**Our Ref: LU/220/18/PL**  
**Your Ref:**

**Development** Alterations & change of use to existing bank (A2 Financial & Professional Services) to mixed use to retail (A1 Shops), office (B1 Business), 3 No. residential dwellings (C3 Dwelling house) & dormer at second floor level (submission following LU/50/17/PL & LU/6/18/PD). This application may affect the setting of a listed building.

**Location** 70 High Street Littlehampton

EAST + NORTH ELEVATIONS - PROPOSED
70 HIGH STREET, LITTLEHAMPTON, SUSSEX.
GRAHAM NICOLLS LTD.

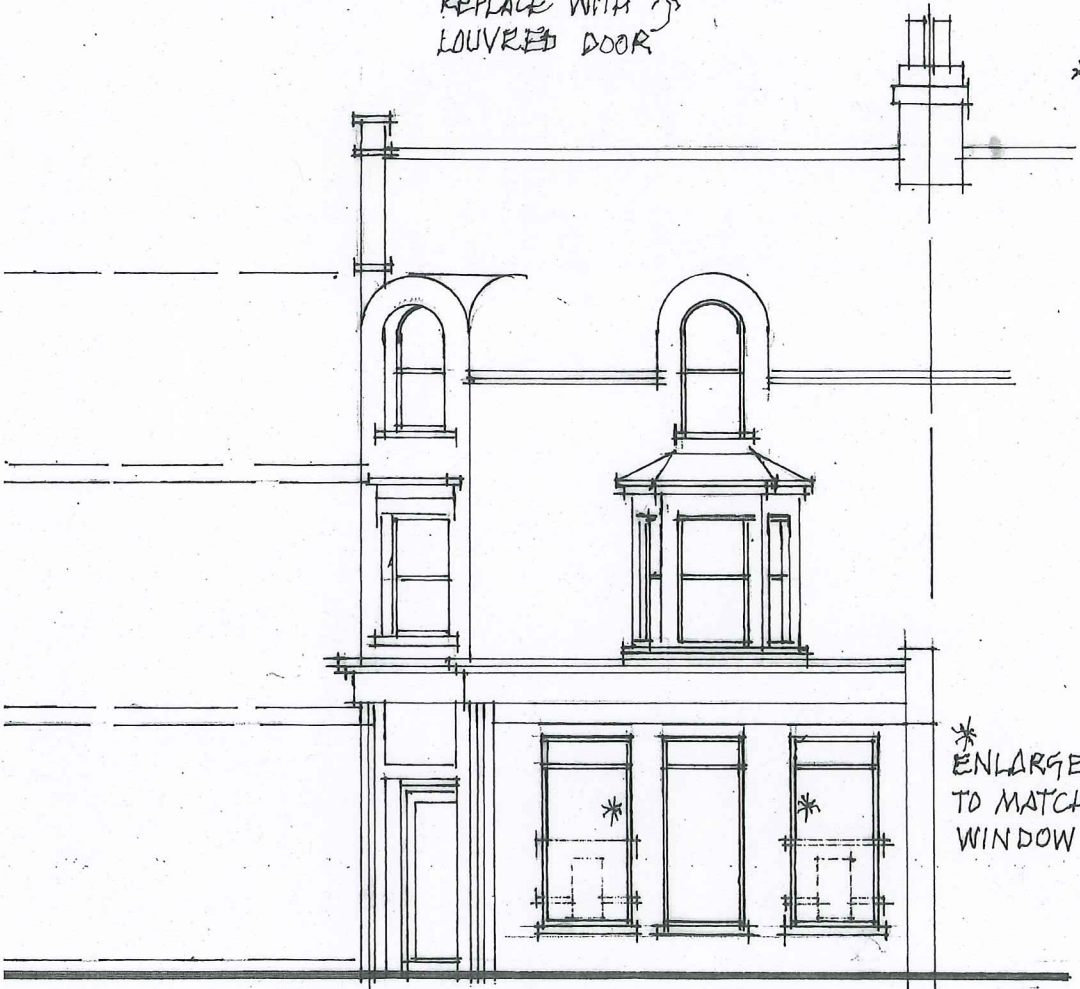
The proposed ground floor plan and east elevation do not accord. Please amend accordingly.
